DEVELOPMENT REVIEW BOARD

Code Enforcement Comments

DRB Project Number: PR-2019-003077

Request: Site Plan

2440 Louisiana
Proposed Hotel
Albuquerque, NM
Landscape Plan

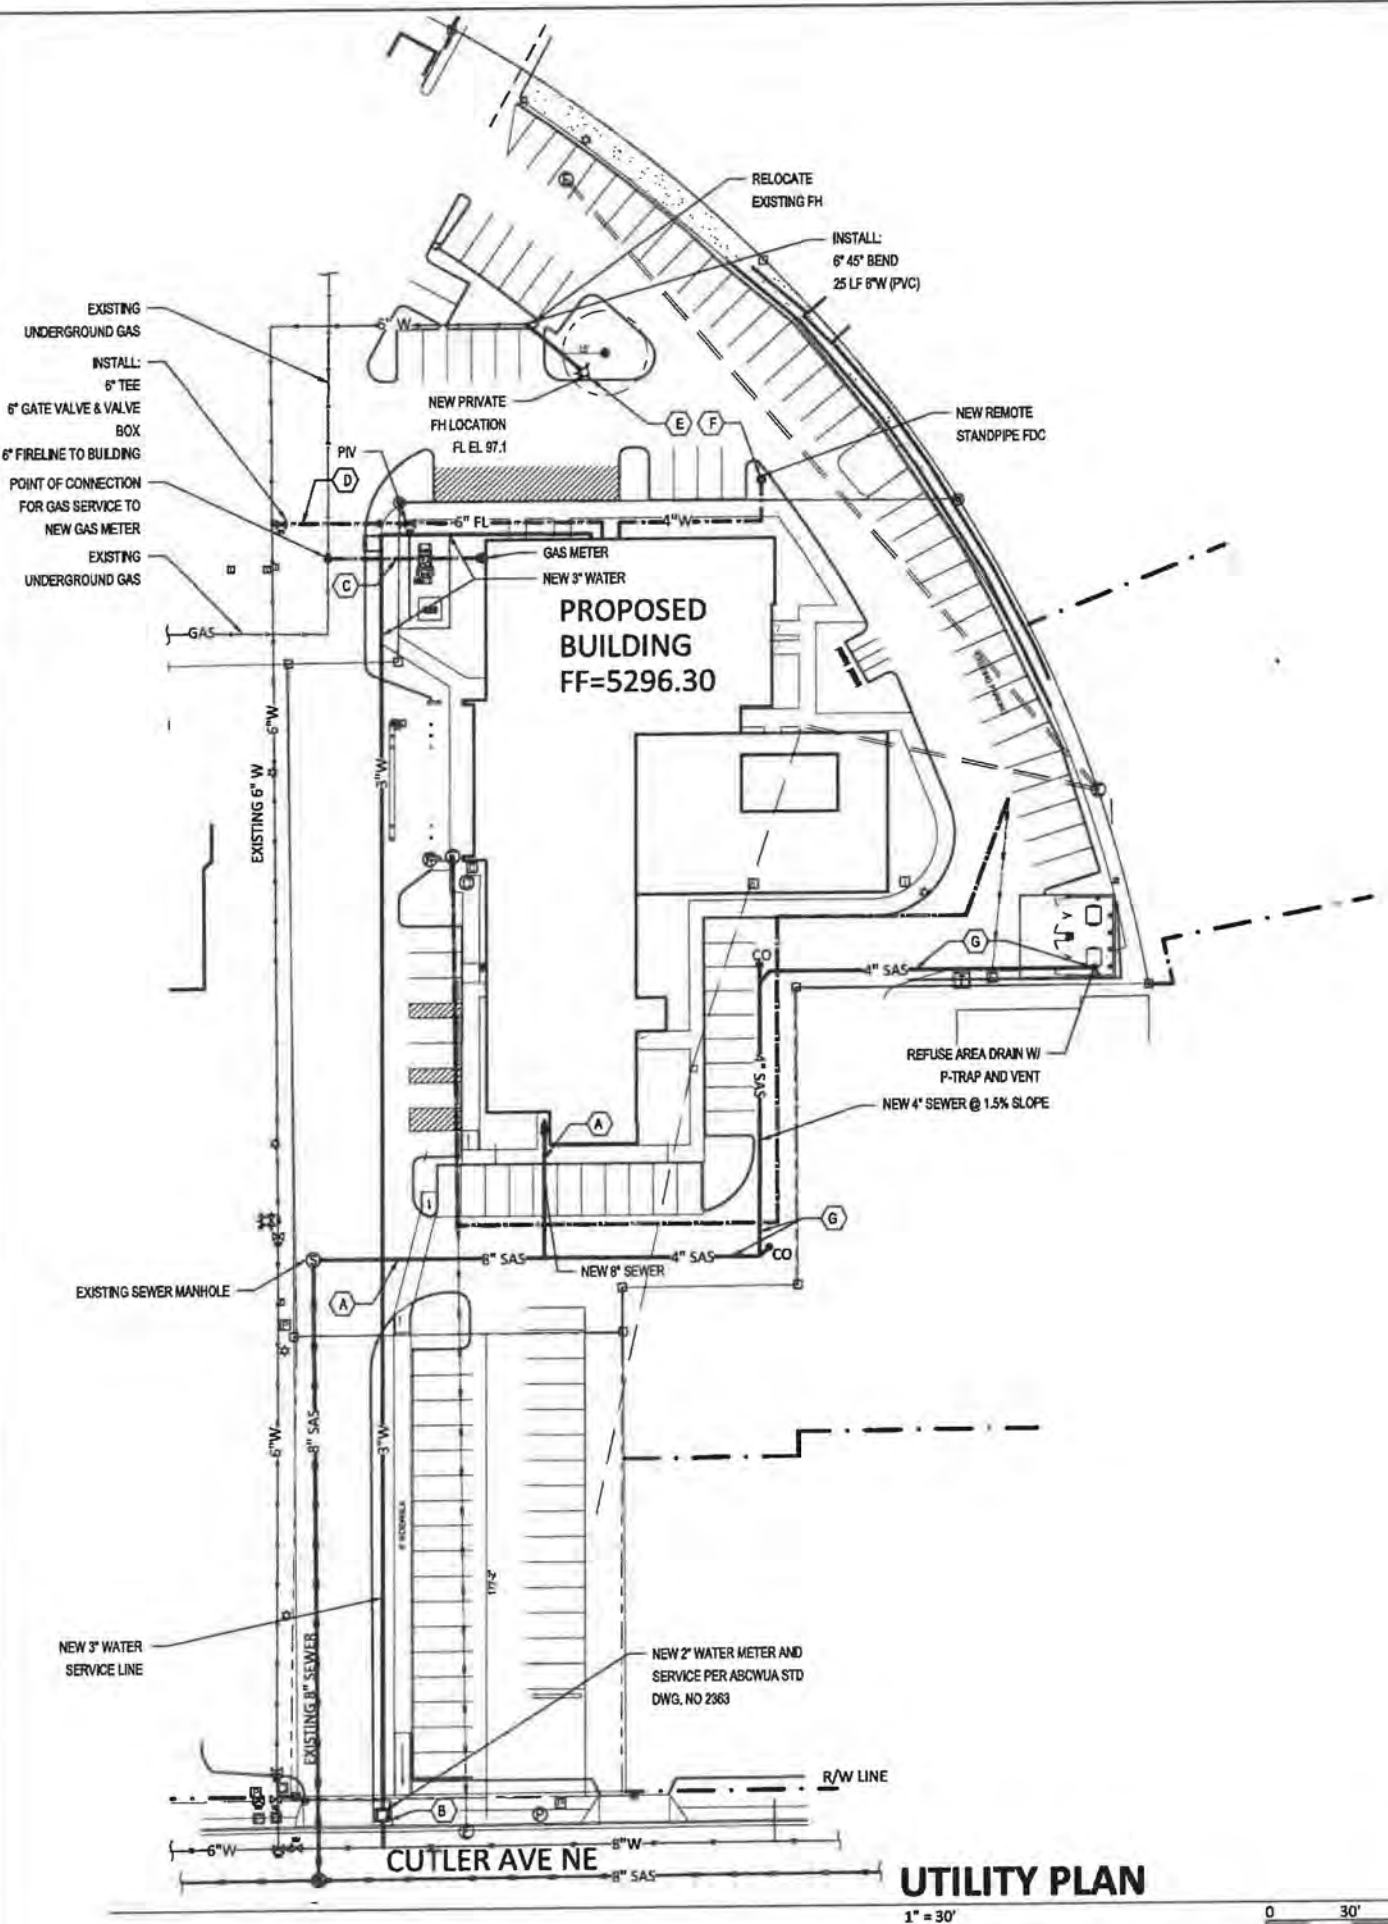
- The use is allowed
- Table 5-5-1. Parking needs to be clarified. Not sure how the calculation of 127 required spaces was made.
- Light pole height. Table 5-8-1 shows a maximum 20 ft pole in a MX zone
- Landscape and Parking. Show landscape plan for parking area.
-
